Road Safety Audit

Wendlebury Road, Bicester

Road Safety Audit
Stage 1

23 May 2019

JOB TITLE		BICESTER CATALYST		CLIENT		ALBION LAND	
DRAWING TITLE							
WENDLEBURY ROAD SITE ACCESS ROUNDABOUT							
SCALE	DRAWN BY	DATE	DRAWING No	REVISION			
1:500@A1	RJM	03/05/19	19539-11-02	A

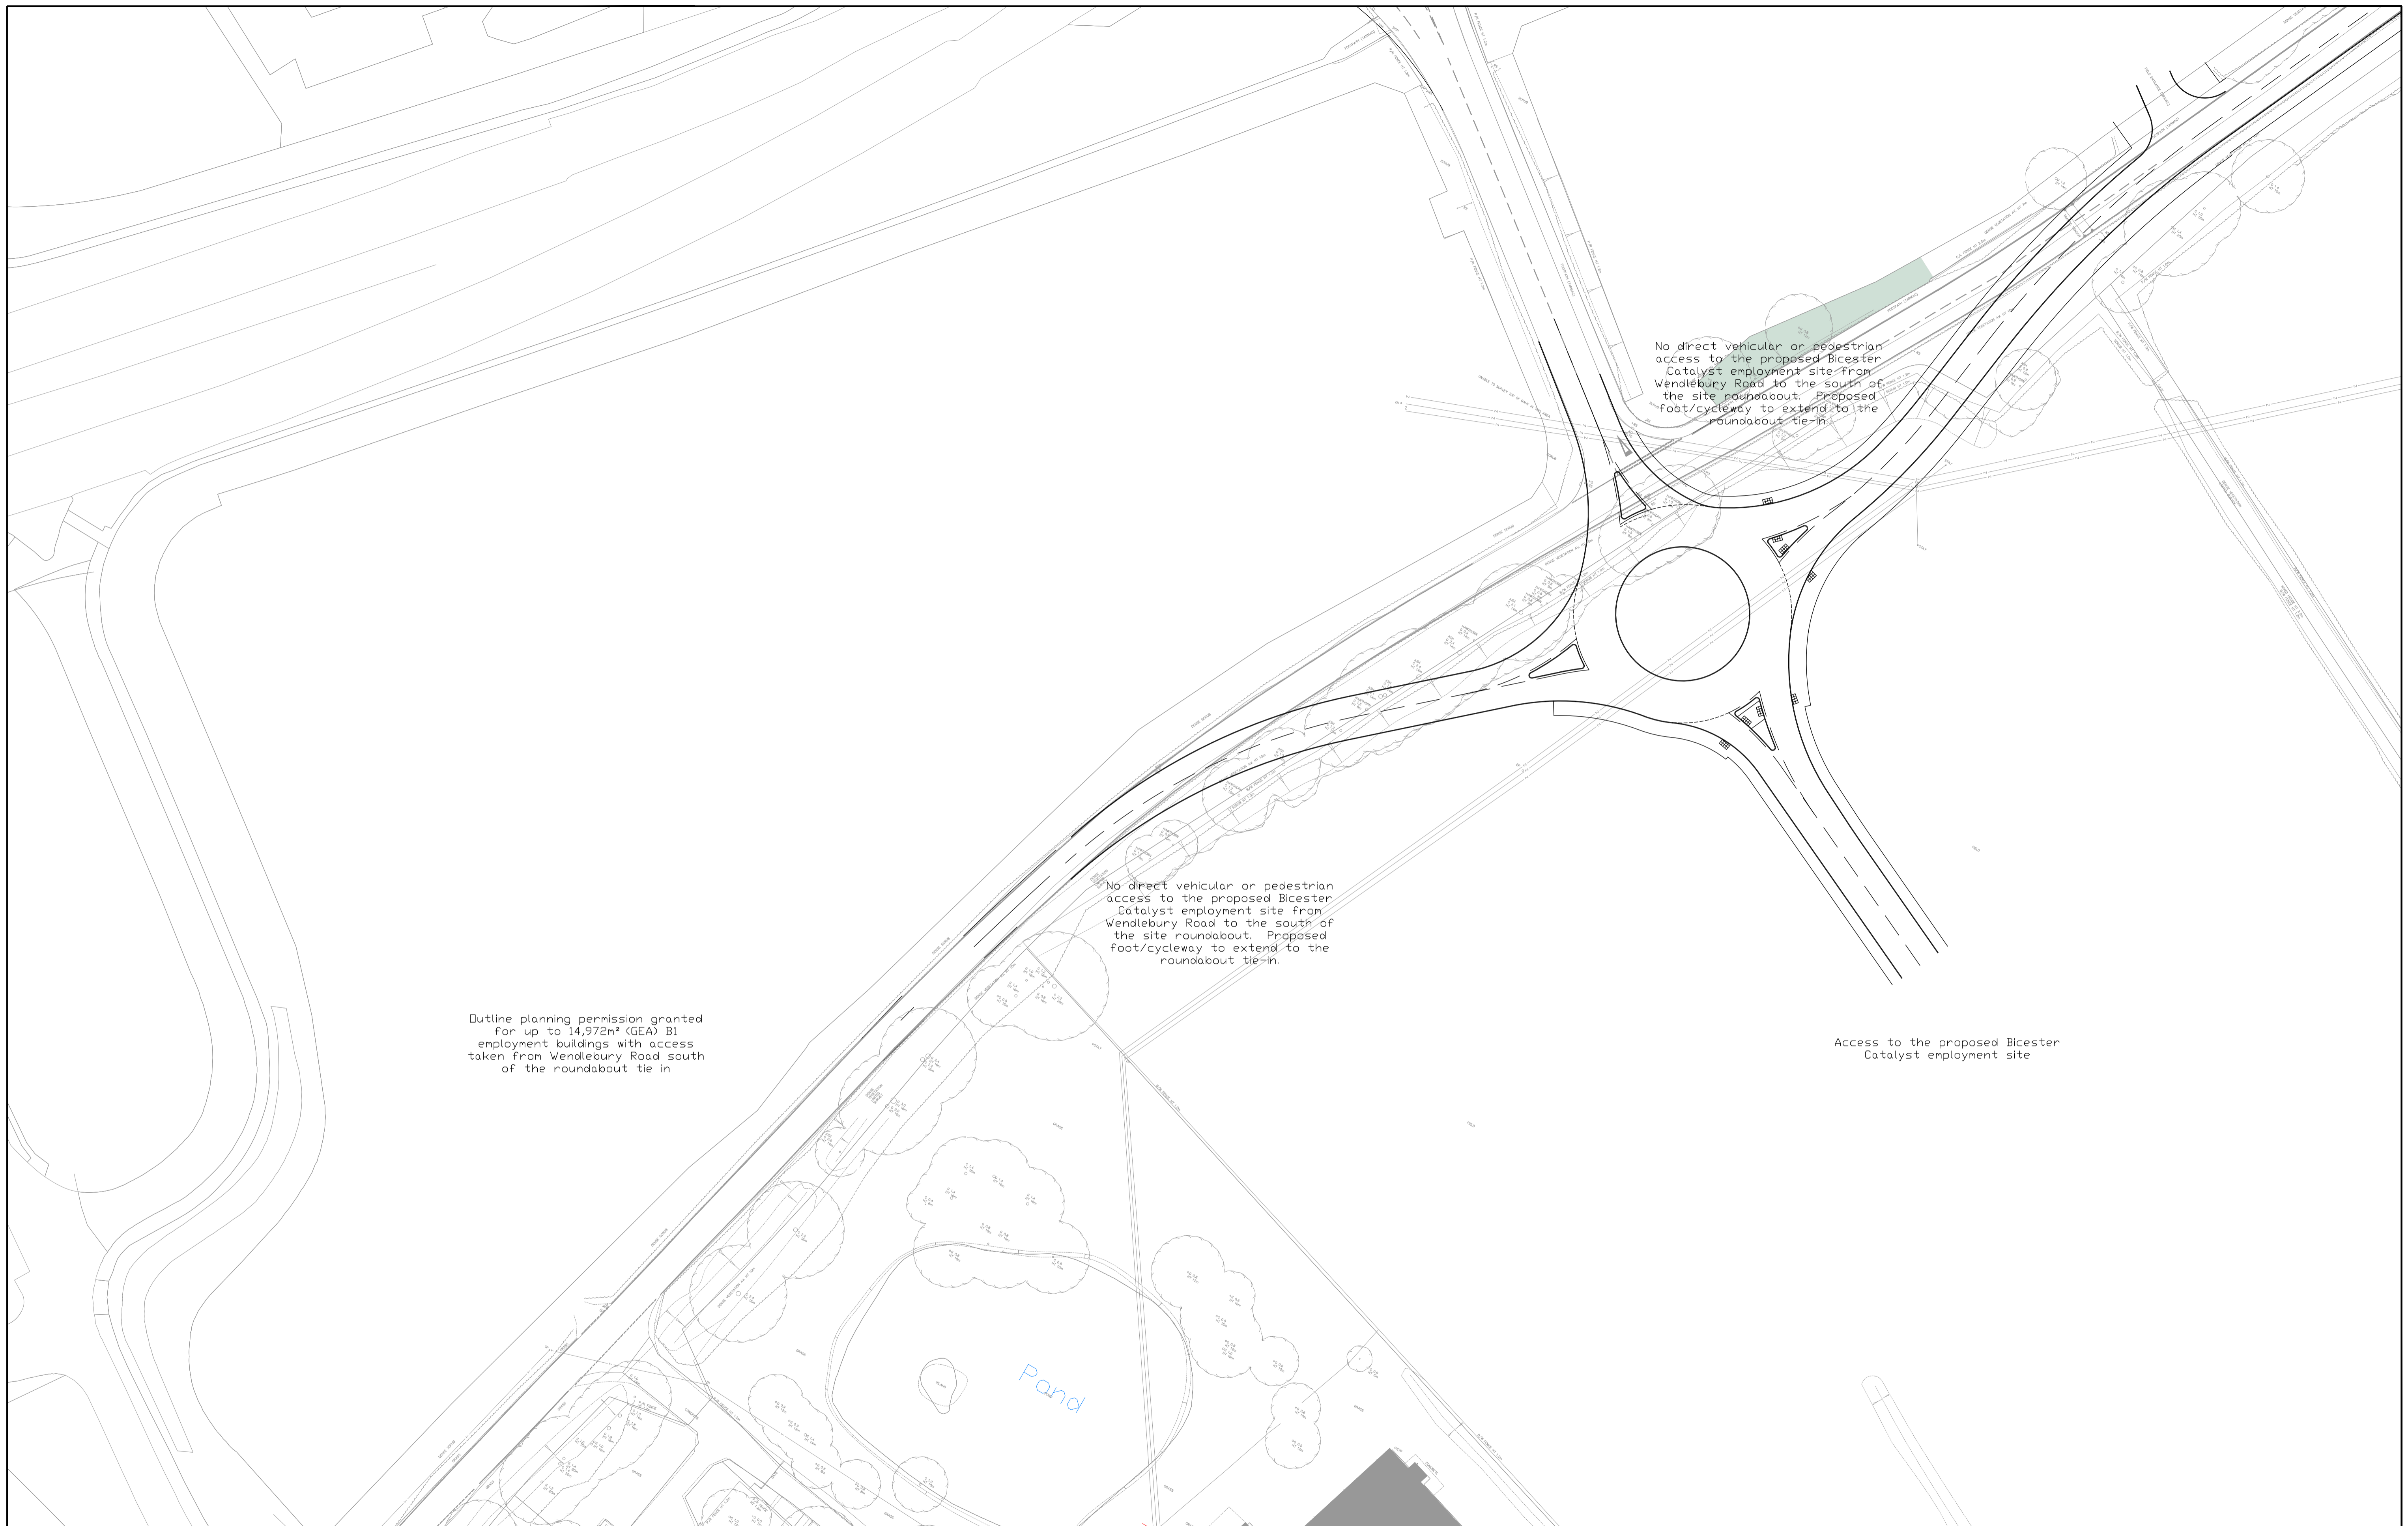
Location: Southern side of Wendlebury Road.

Summary: Drop at back of footway may present a hazard to pedestrians.

A new 2.5m footway / cycleway is proposed along the southern side of Wendlebury Road. There is an overgrown ditch running the length of Wendlebury Road throughout the scheme, with a noticeable level difference from the carriageway level to the bottom of the ditch. Provision of a footway at this location will result in drop at the back of the footway, which may present a hazard to pedestrians or cyclists should they leave the paved surface. This may result in falls resulting in personal injury.

Location: Wendlebury Road – western extent of scheme.

Summary: Unclear end of footway / cycleway.

A new 2.5m footway / cycleway is proposed along the southern side of Wendlebury Road. It is proposed that this will continue to the west of the proposed roundabout, but there are no existing footway / cycleway provisions on this side of the junction. It is unclear if there will be a demand in this direction and therefore the continuation of the footway / cycleway may encourage users continuing to the west to enter the carriageway increasing their vulnerability to being struck.

It is recommended that a fence or guardrail is provided at the back of the footway wherever a drop to surrounding surface levels is present. Alternatively, ground at the back of the footway should be graded to avoid a steep drop.

It is recommended that appropriate tie-ins with surrounding facilities are provided. If no pedestrian / cyclist demand is anticipated in this direction, the footway / cycleway to the west of the roundabout should be omitted from the scheme.
